My ref: RLS/18/02/17/AR
Your ref: A/55/19/PL

11th June 2019

Revised Application for a single Dwelling.
Land at the Ninth Tee, Land North of Ashurst, Ham Manor Way, Angmering.
Your Ref: A/55/19/PL

Site Plan (1:200)

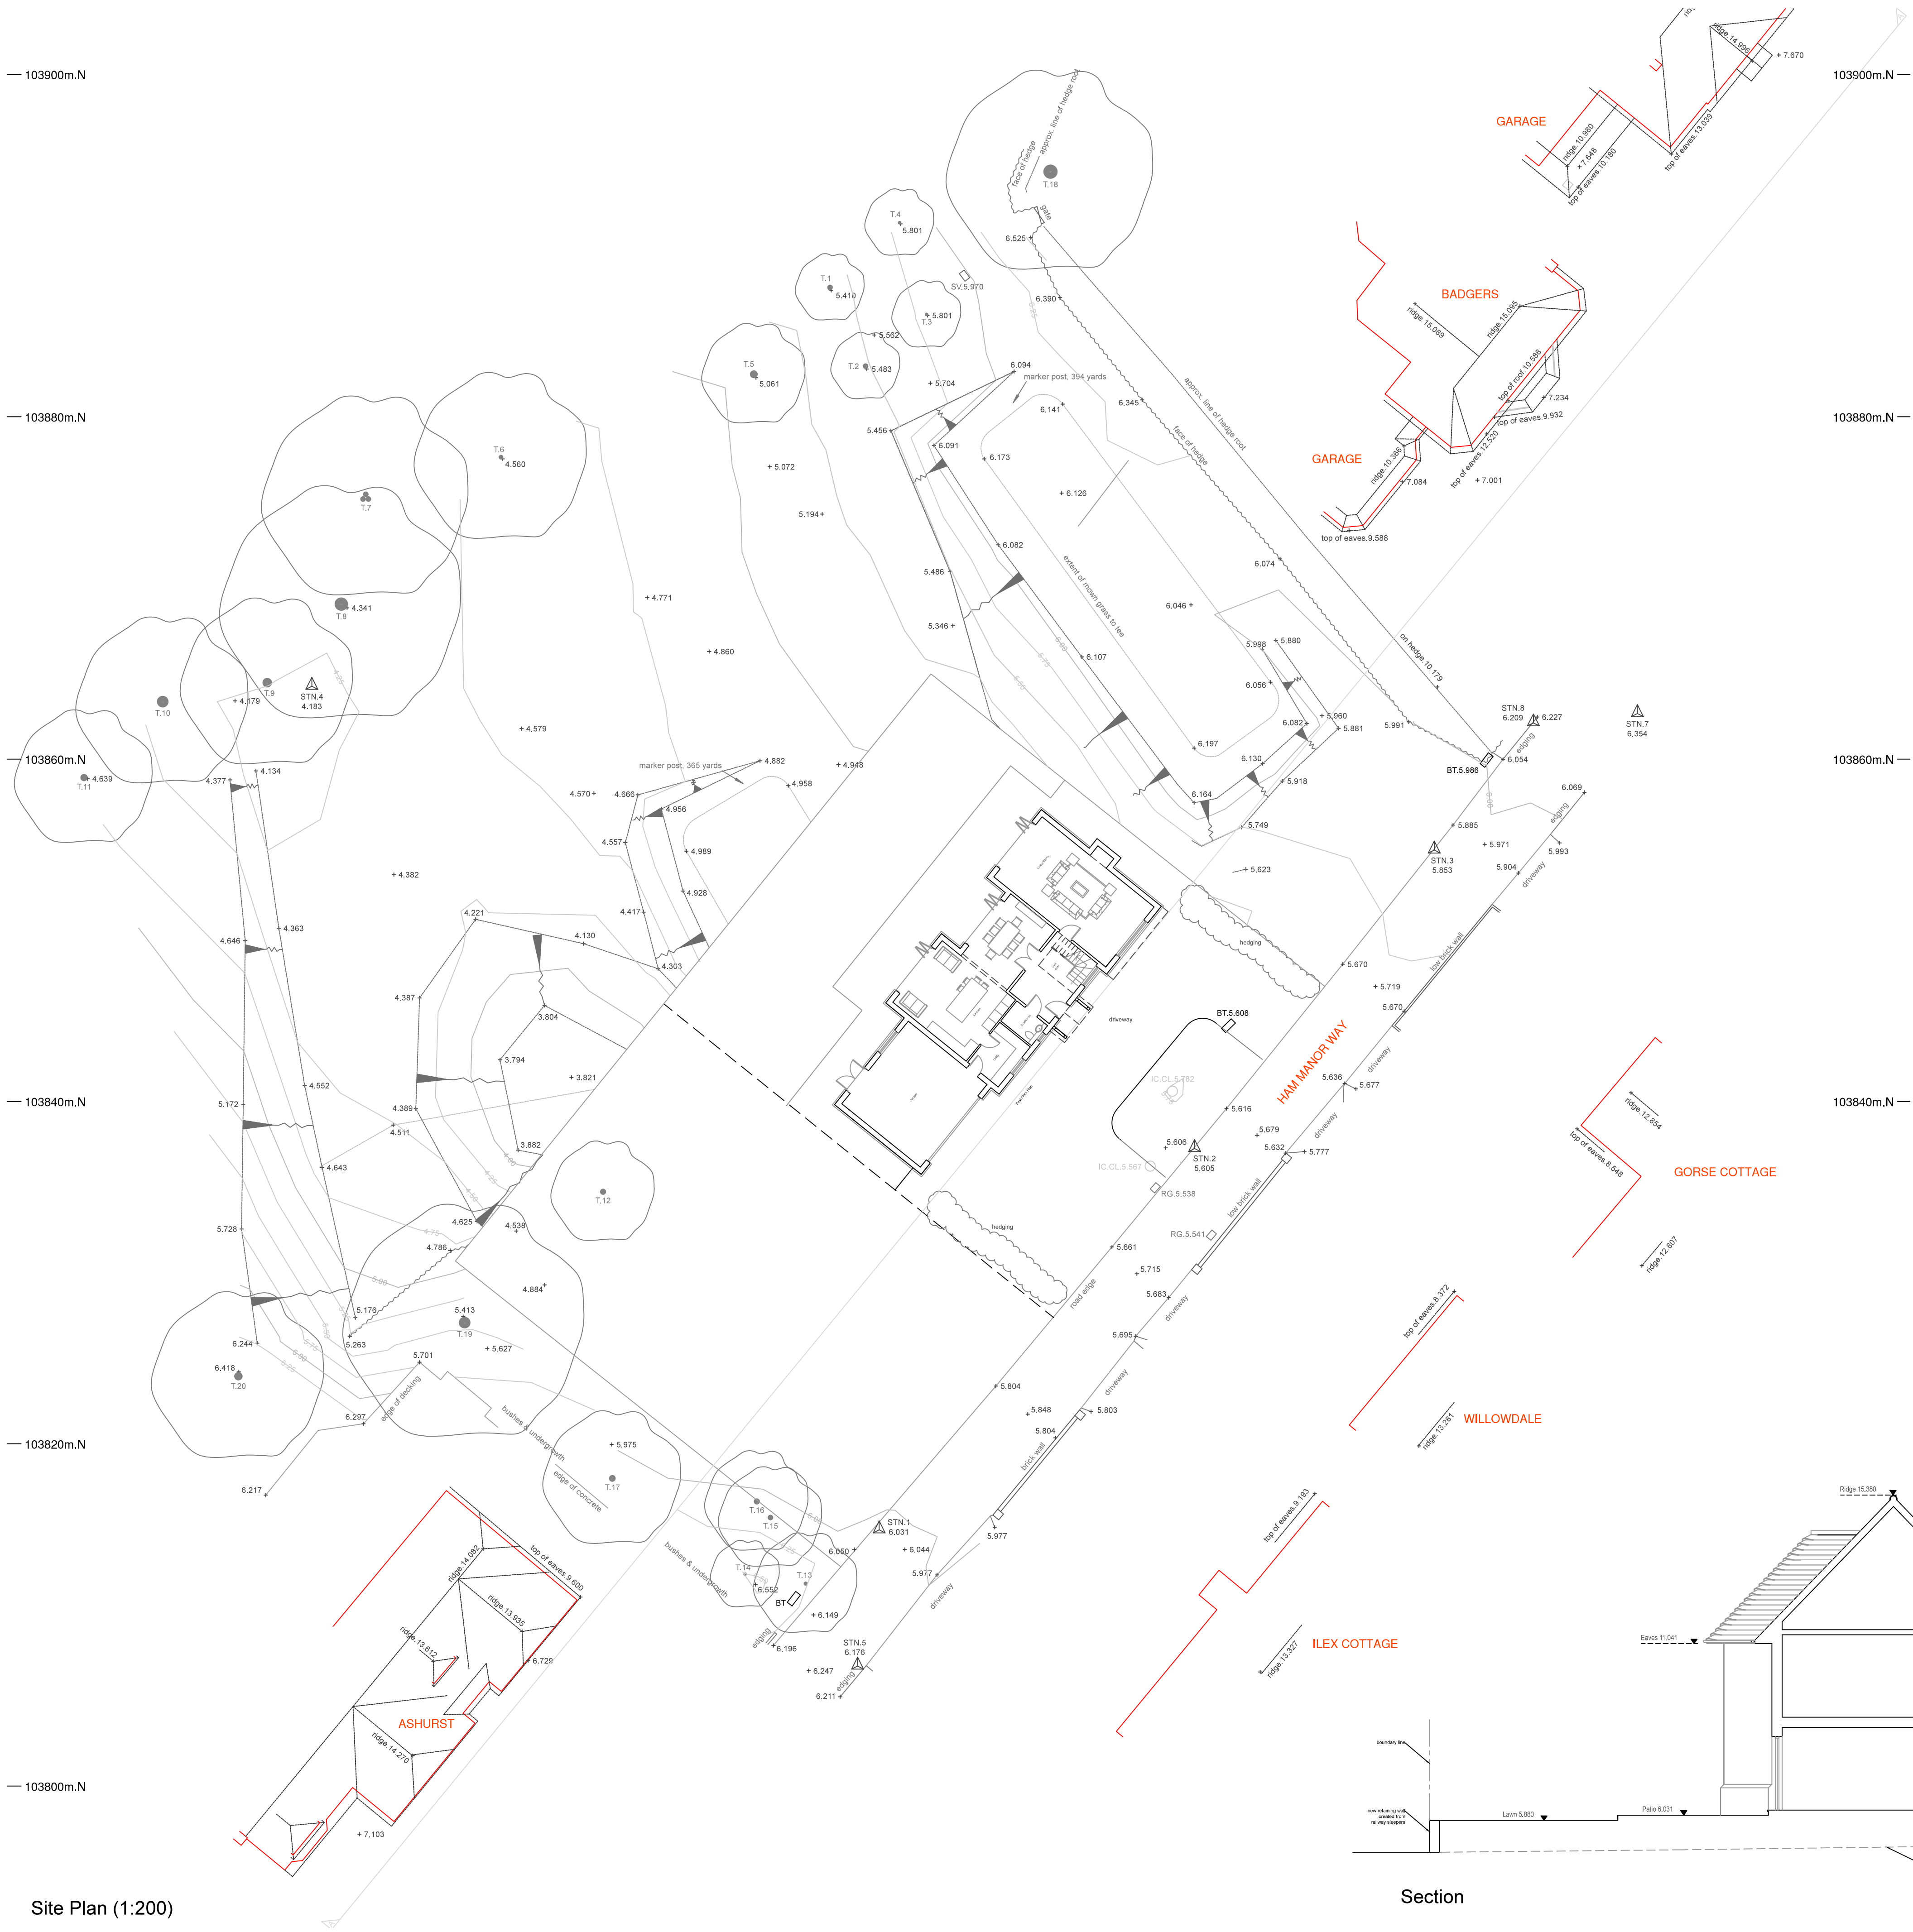
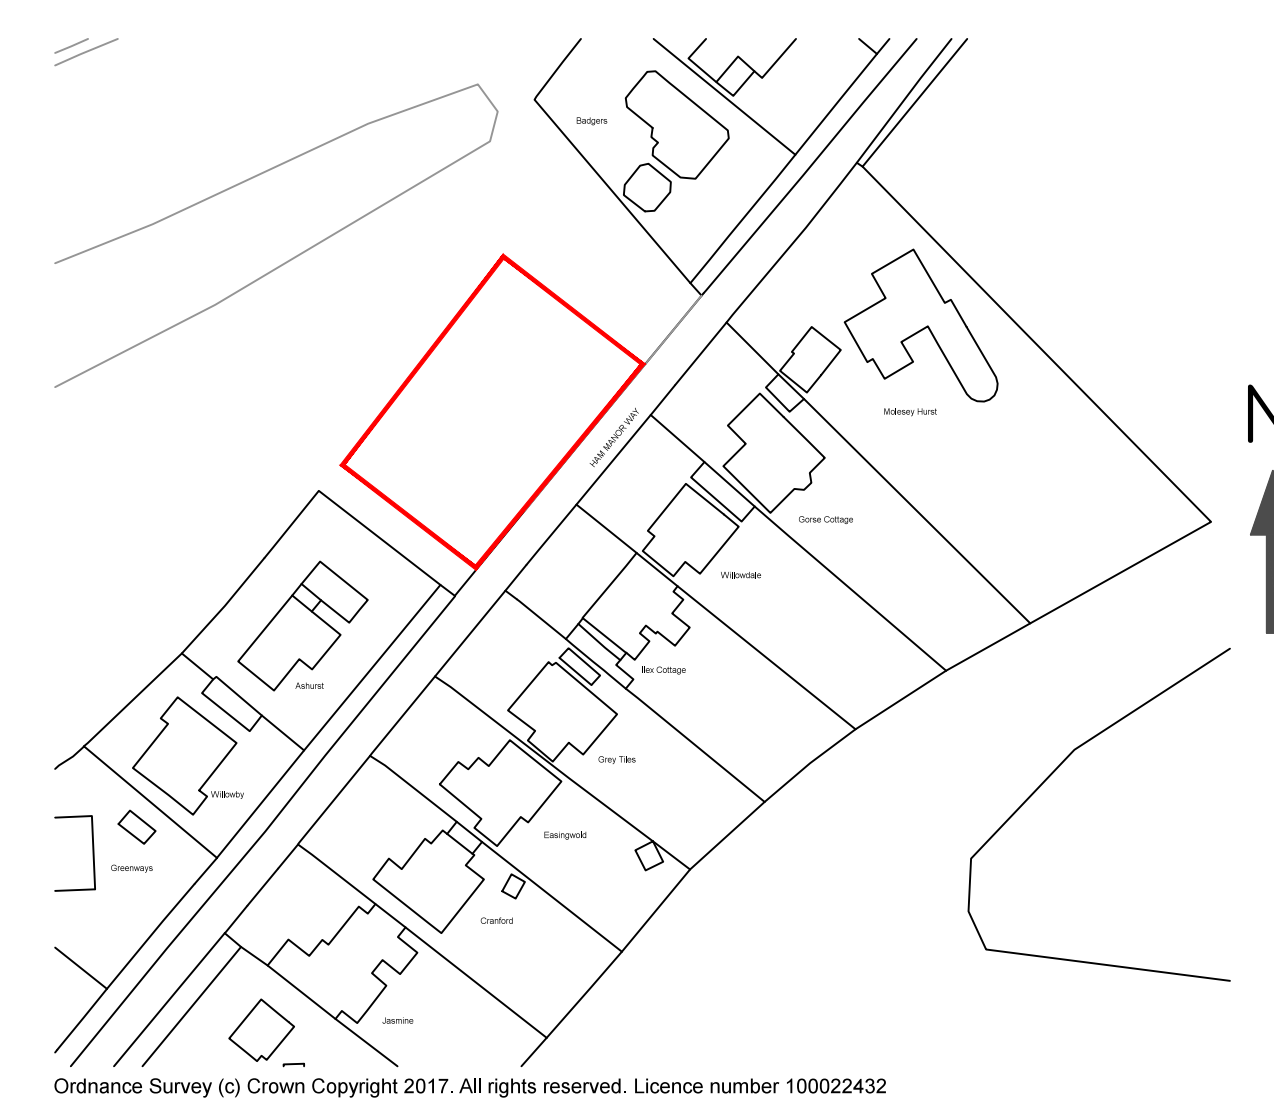
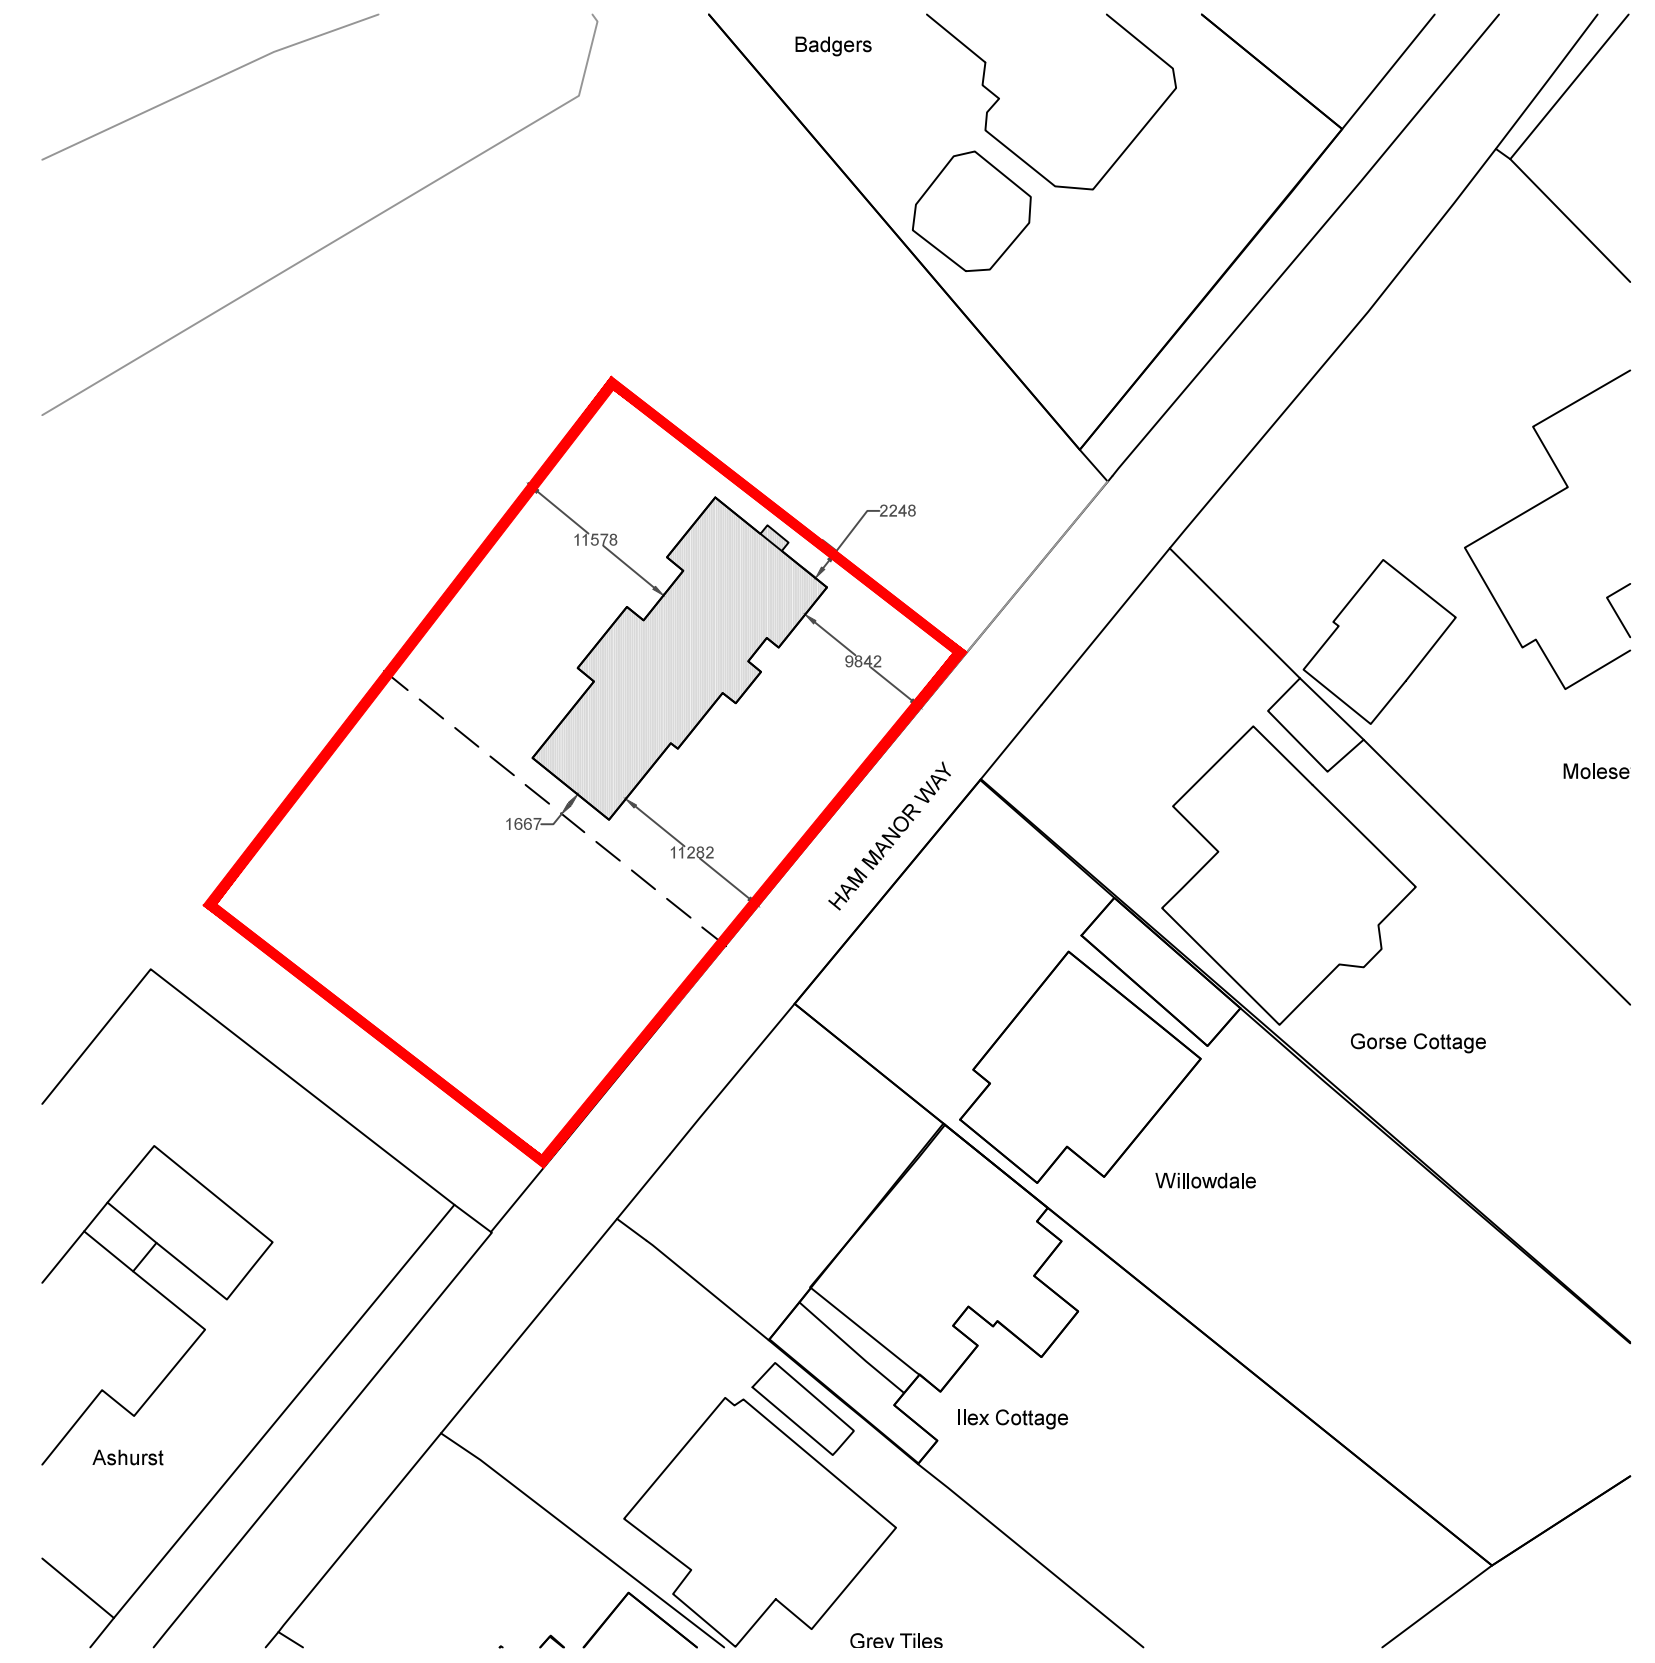
In addition whilst the width of the plot has reduced the depth (east to west) has increased and I fail to understand the applicant's stated submission on the application drawings that this is correct when no change has been made to either the site plan or the block plan with the red edges to the site being the same as on the previous application. The claim that is made is that this is the same site as the LDC application and appears incorrect for the same reasons. My assessment of the rear garden depth of Ashurst from the submitted block plan remains as 24 metres max (7 + 10 + 7) from the detailed plans submitted (your reference A/115/16/HH) but the depth of this site now appears greater. The claim made at the time the LDC was granted was that this was correct to applications promoted in 1949 and 1957, which I would challenge, but in any event you clearly cannot now agree a deeper plot arising from this proposal which clearly goes into the protected Local Green Space.

Lastly, in dealing with this plot depth the submitted plans to the rear of Ashurst show a reduced boundary on the west boundary adjacent to this site. In the northwest corner the site is shown to cut back in for the northern part of this site on the detailed drawings. I would describe this as a "dog leg" on the west side boundary. If this is correct then which boundary is the true boundary on the west side of Ashurst irrespective as to whether or not this western boundary to Ashurst is actually correct in comparison to the 1949 or 1957 permissions? This I would suggest is vital in determining the depth of the proposed site as is claimed by the applicant for these proposals. It is perhaps vital that the correct depth and width of the lot from the 1949 or 1957 site is correctly and accurately plotted.
